REQUEST

Current Zoning: I-1(CD) (light industrial, conditional) and R-22MF (multifamily residential)
Proposed Zoning: I-1(CD) (light industrial, conditional) and I-1(CD) SPA (light industrial, conditional, site plan amendment)

Approximately 9.54 acres located north of Perimeter Pointe Parkway, west of Rebecca Avenue, and south of West Boulevard.

The petition proposes to allow all uses permitted in the I-1 zoning district with the exception of Eating, Drinking, and Entertainment Establishments (EDEE) with accessory drive-through uses. The petition would allow a portion of the entitlements remaining from Rezoning Petition 1998-125 to be developed.

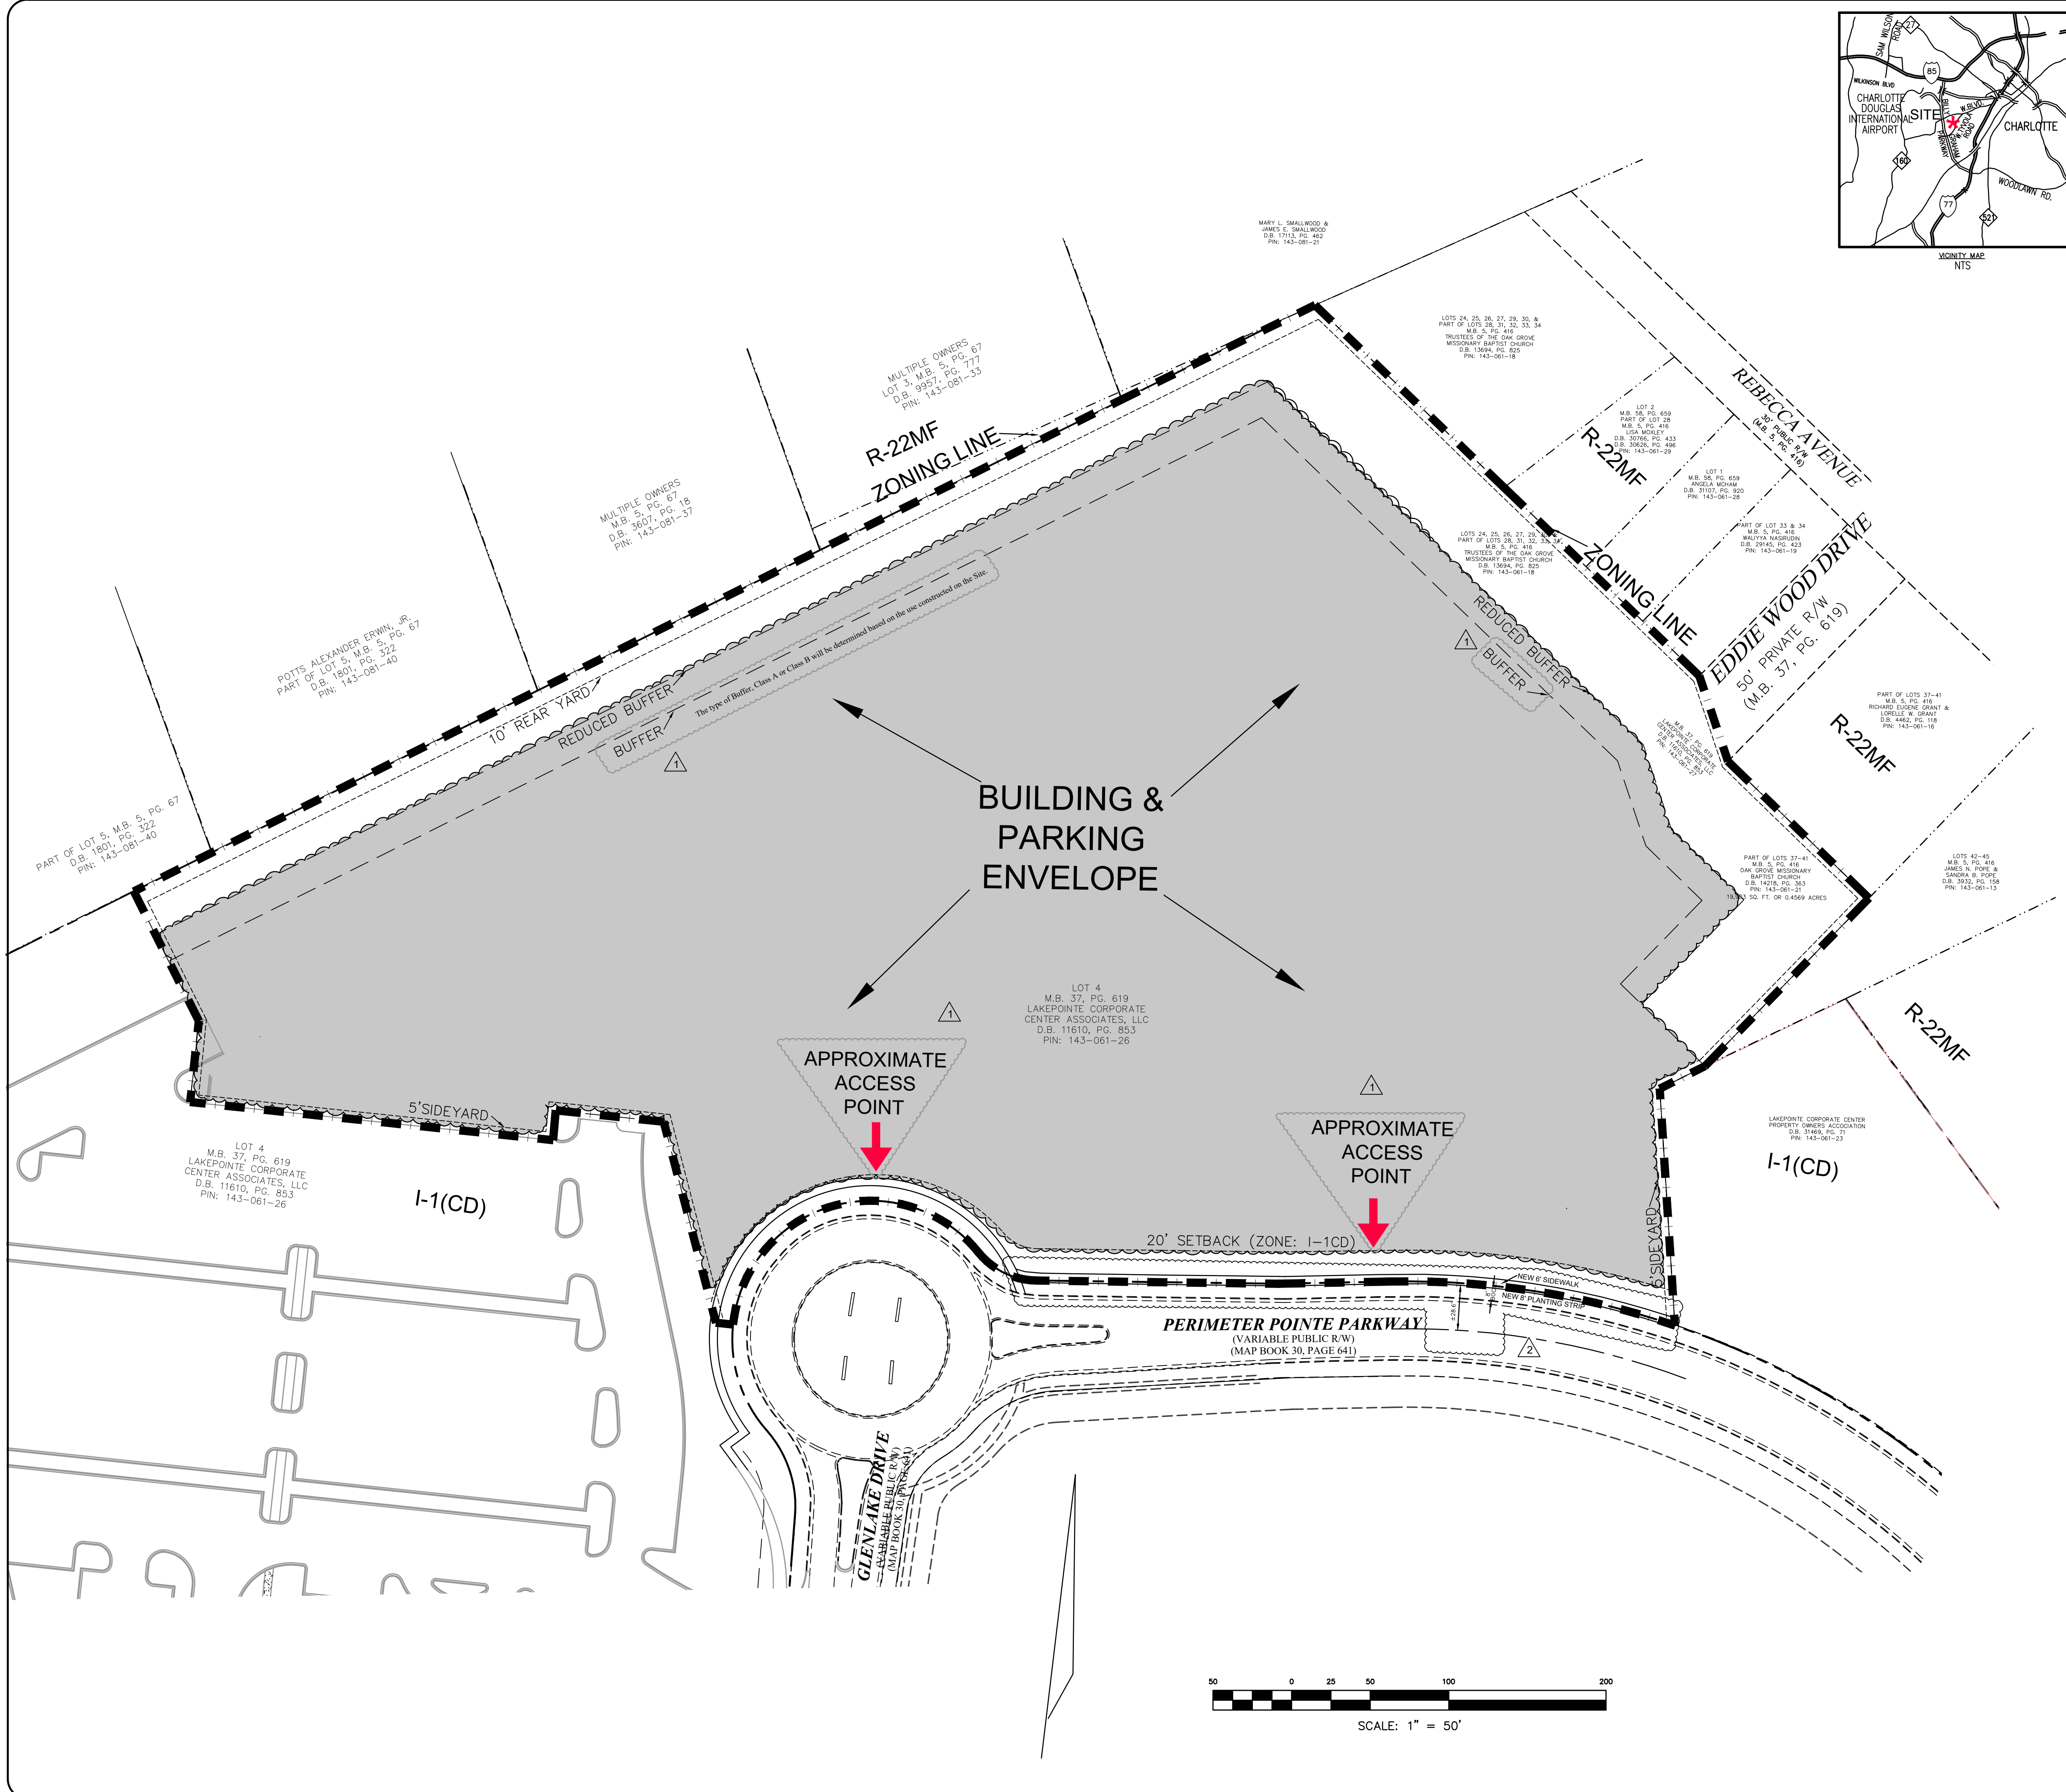
1. Revise the site plan and conditional note(s) to commit to construct an 8-ft planting strip, and 6-ft sidewalk on Perimeter Pointe Parkway as per Charlotte WALKS. This sidewalk need to tie into the existing network at the adjacent parcel, 14306125, and extend to the curb ramp at Tyvola Road. Label and dimension both items from the back of curb and gutter and road centerline. **CDOT strongly suggests the 8-foot planting strip and sidewalk be extended east, along Perimeter Pointe Parkway, to the existing curb ramp at Tyvola Road. The adjacent, undeveloped, parcel is listed as common open space, in the Mecklenburg County Tax Records, for the Lake Pointe Corporate Center and is not subject to further development. OUTSTANDING**
